CPP Project 8366

Project: Sydney One - Tower B

Please find herein an assessment of several wind related considerations on the proposed Sydney One - Tower B development. This opinion based assessment follows on from the results of wind tunnel testing of the proposed development presented in the report "CPP8366_Sydney One_REP_PW_R02", dated 20 October 2016.

GROUND - LOBBY HOTEL & RETAIL

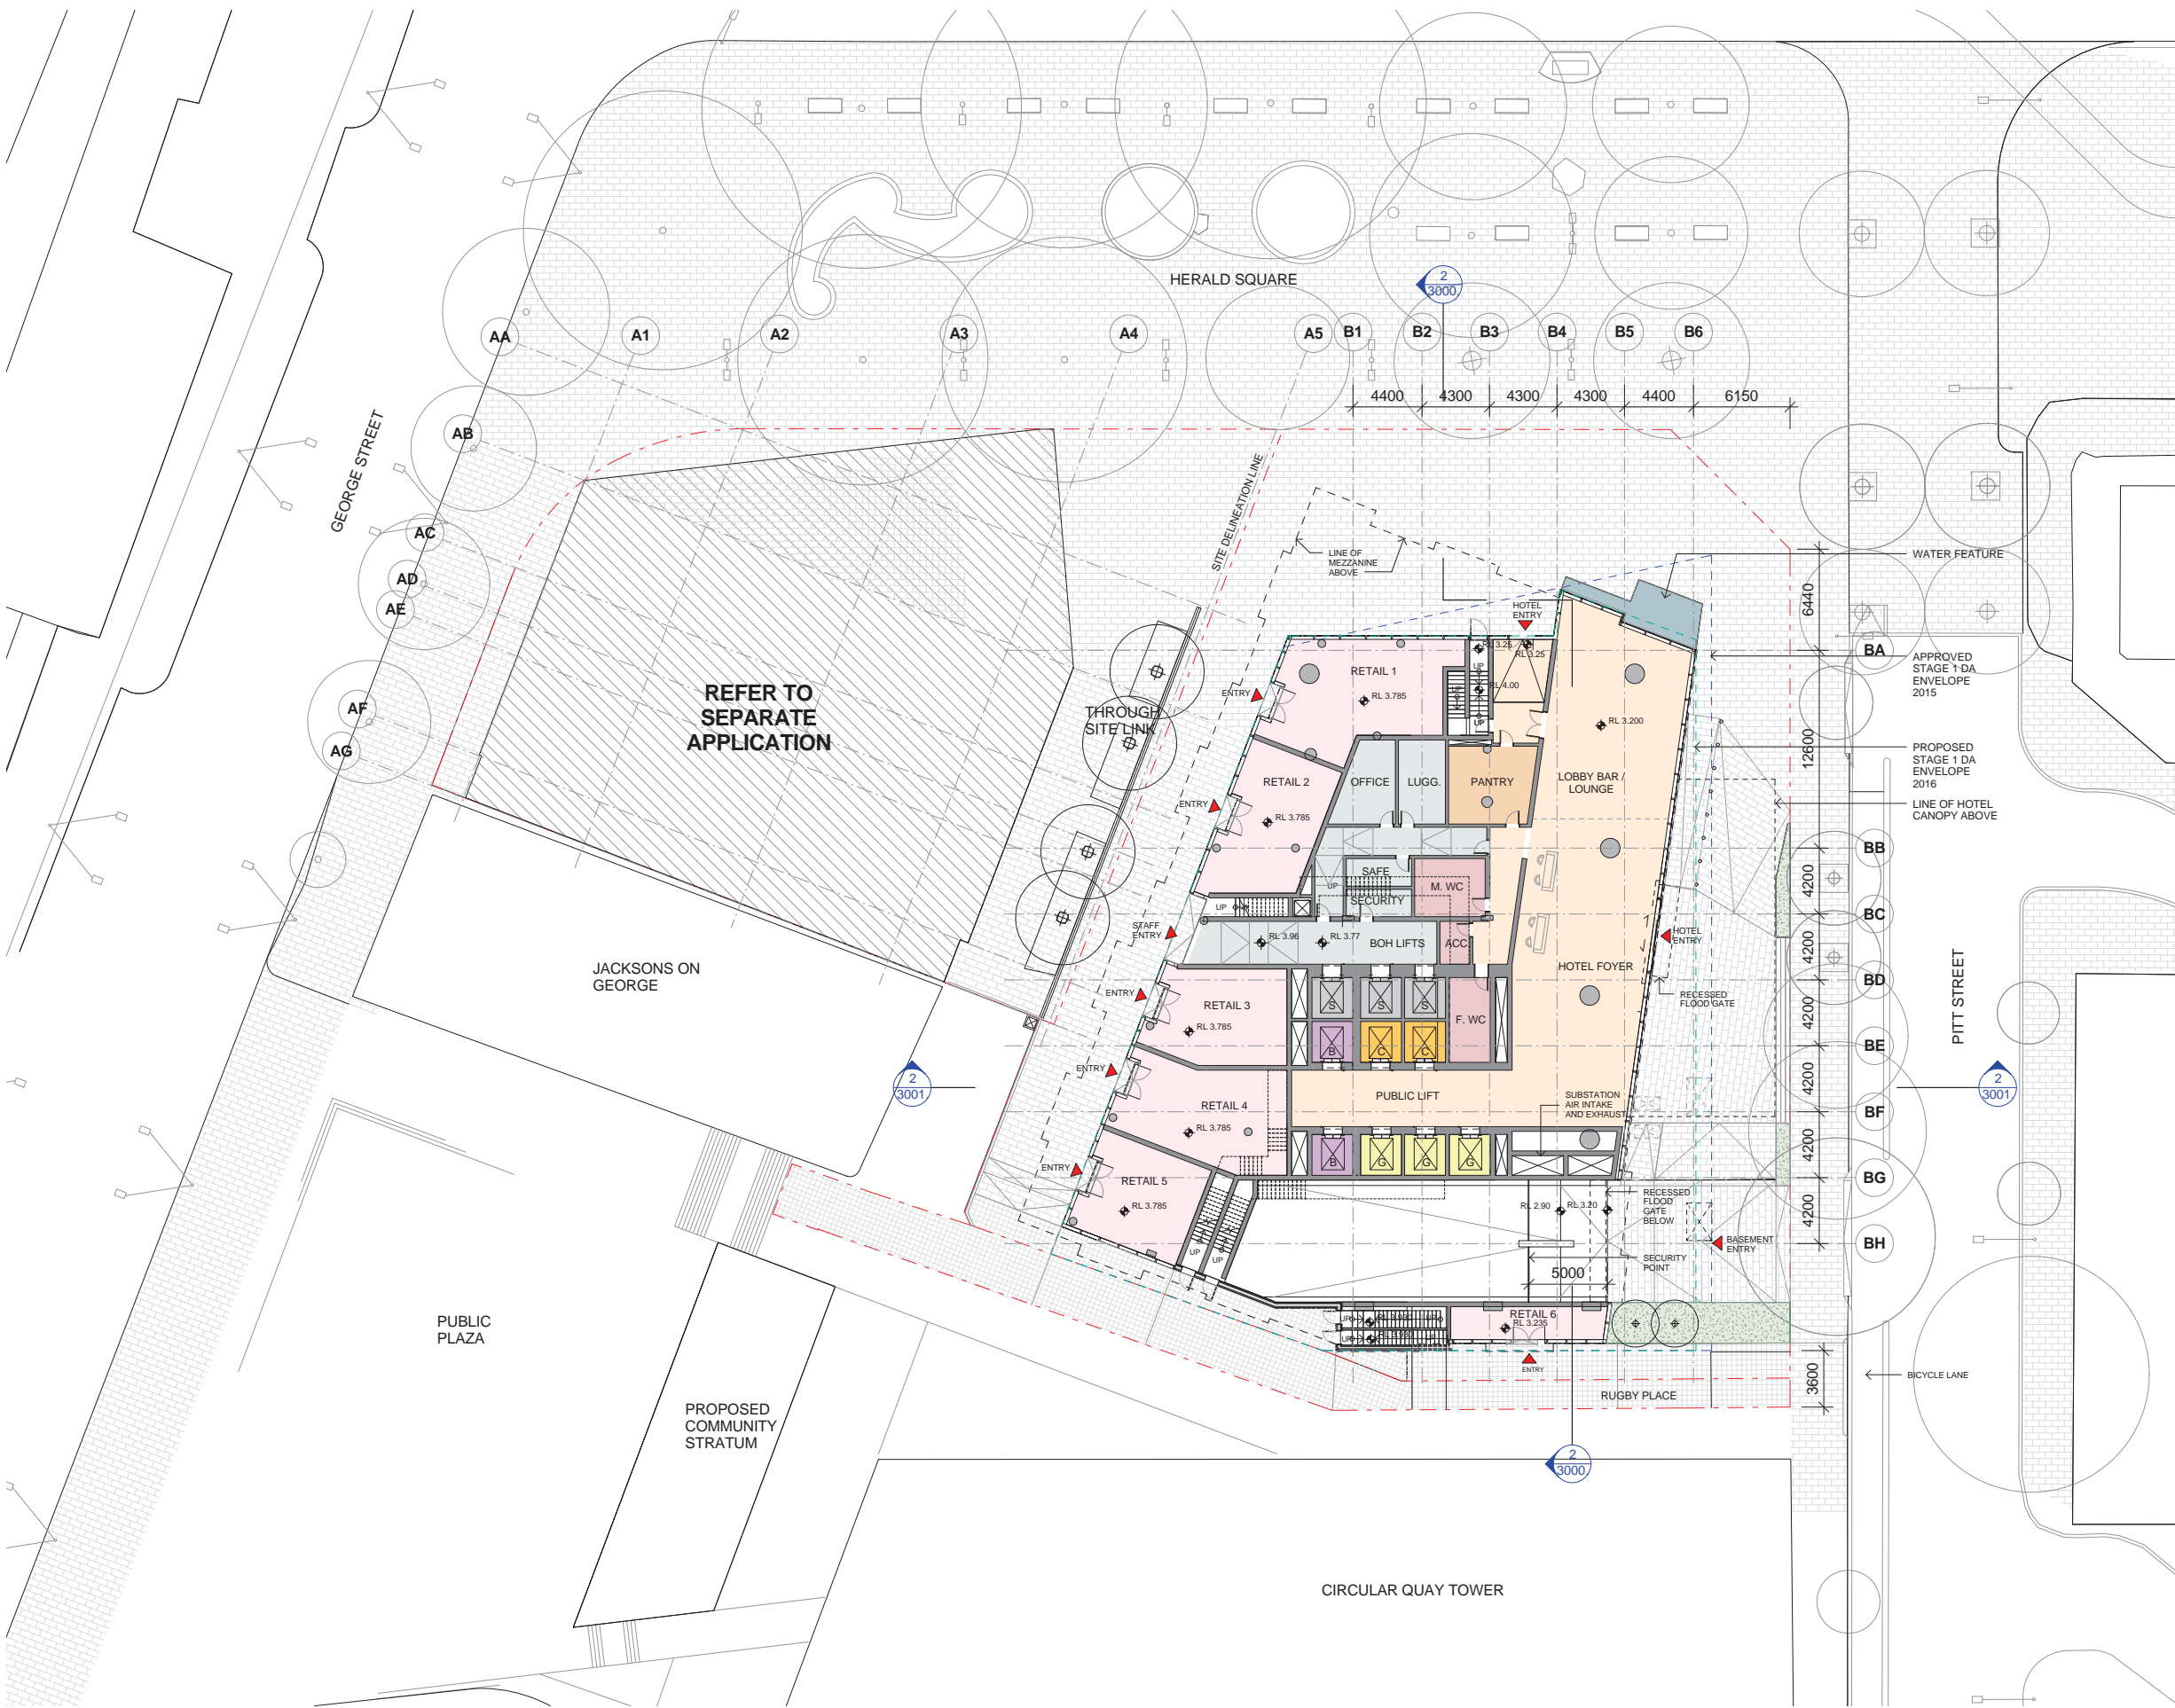
It is understood that concerns were raised with regards to potential spray from the planned still water feature on the north-eastern corner of the proposed development, Figure 1. Cross-sectional details of the water feature, and the intended operational conditions would be required to fully comment, but it is assumed that the feature consists of a raised pool of water, which spills over the north, east, and west perimeter edges into a lower drainage zone. It is understood that the maximum depth of the water in the pool is 200 mm, the maximum height of the water fall over the edge is 600 mm, and the depth of flow at the crest is significantly less than 10 mm. With such a shallow depth of water the speed of flow would be expected to be minimal. A seating area is intended immediately west of the water feature. The wind tunnel test results show that the location is generally suitable for pedestrian standing activities, and exceeds the wind speed associated with the pedestrian sitting criterion approximately 10% of the time, Figure 2. The directional wind speeds at this location, Figure 2(R), indicate that the location is exposed to strong winds from the north quadrant, which would result in accelerated winds around the north-east building corner. Based on these results, spray water is primarily of concern to the eastern side of the water feature, particularly with wind accelerating along the higher north wall of the feature breaking up the slow-moving shallow flow and transporting the smaller particles with the flow. Depending on the geometry of the feature and the flow rate, during strong winds the intended 300 mm wide drainage perimeter zone around the feature may be insufficient.

The north-east corner of the water feature is expected to be the most critical point in which the wind is most likely to pick up water droplets and transpose them laterally. A moderate wind speed of 5 m/s from the north-west quadrant would be expected to be sufficient to wet an area of approximately 1 m to the south-east of the corner. These wind conditions would be exceeded approximately 7% of the time according to data from the Sydney Airport Bureau of Meteorology anemometer. To reduce the risk of spray, it would be recommended to prevent the water from flowing over this corner. Simple detailing of this edge to minimise

the risk of wind-driven spray will be developed during detailed design.
